Our Ref: BN/26/15/RES
Your Ref:

Application for Approval of Reserved Matters Following Outline Approval

Development Approval of reserved matters following outline consent BN/7/12/ for 44 No. dwellings including 30% affordable, comprising of a mix of 2 & 4 bed houses with associated landscaping & works. This application is a Departure from the Development Plan.

Location Land North of Yapton Road and East of Garden Crescent Barnham

Plots 33 & 34 (as)
Plot 32 (handed)

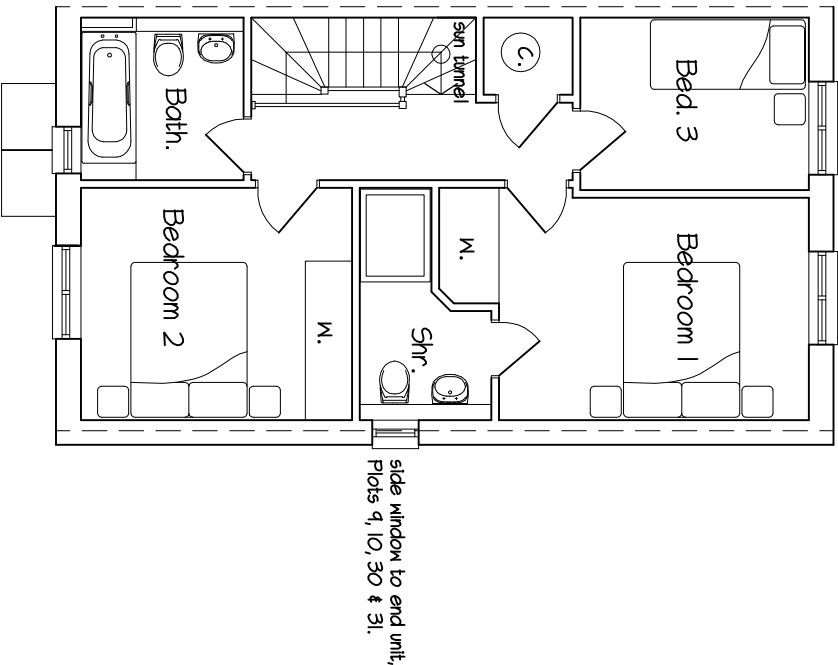
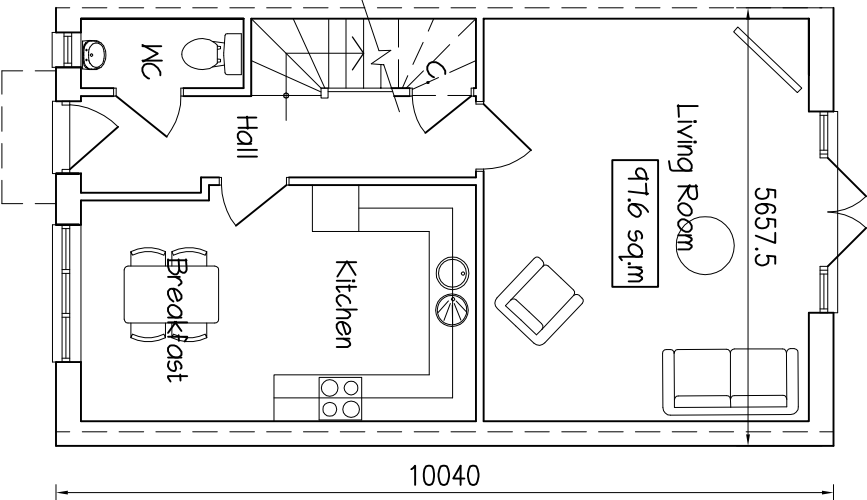
Plots 32 and 34 North and South ground floor plans and elevations do not accord. Please amend accordingly.

End terrace, side access units - market.
Plots 11 (handed) & 13 (as).

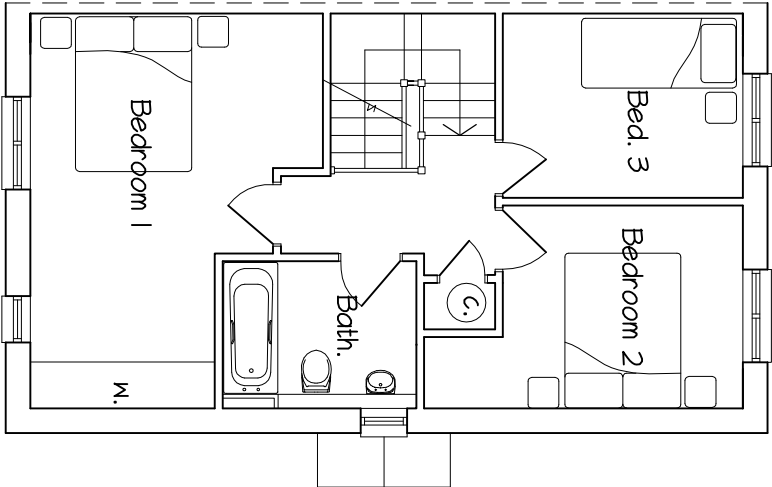
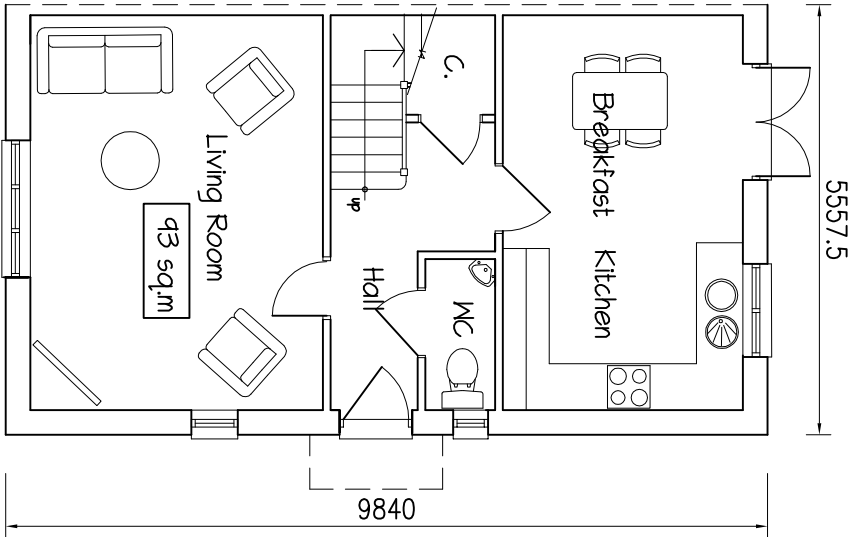
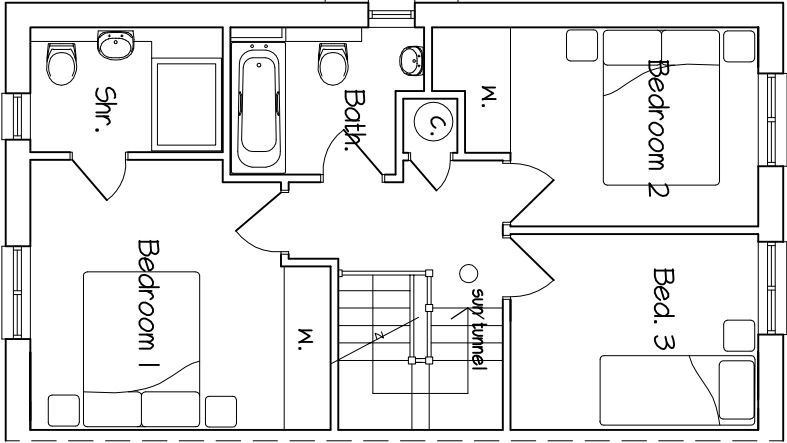
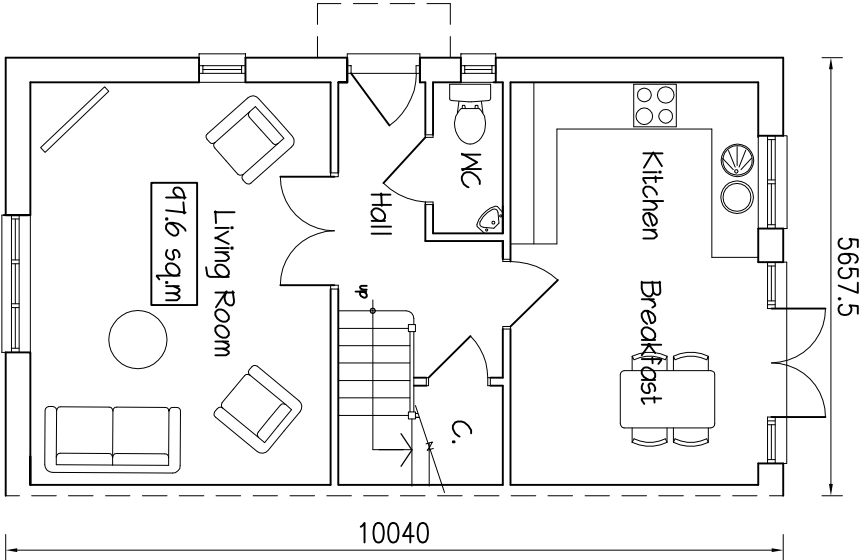
Plots 11 and 13 rear ground floor (East) floor plans and elevations do not accord. Please amend accordingly.
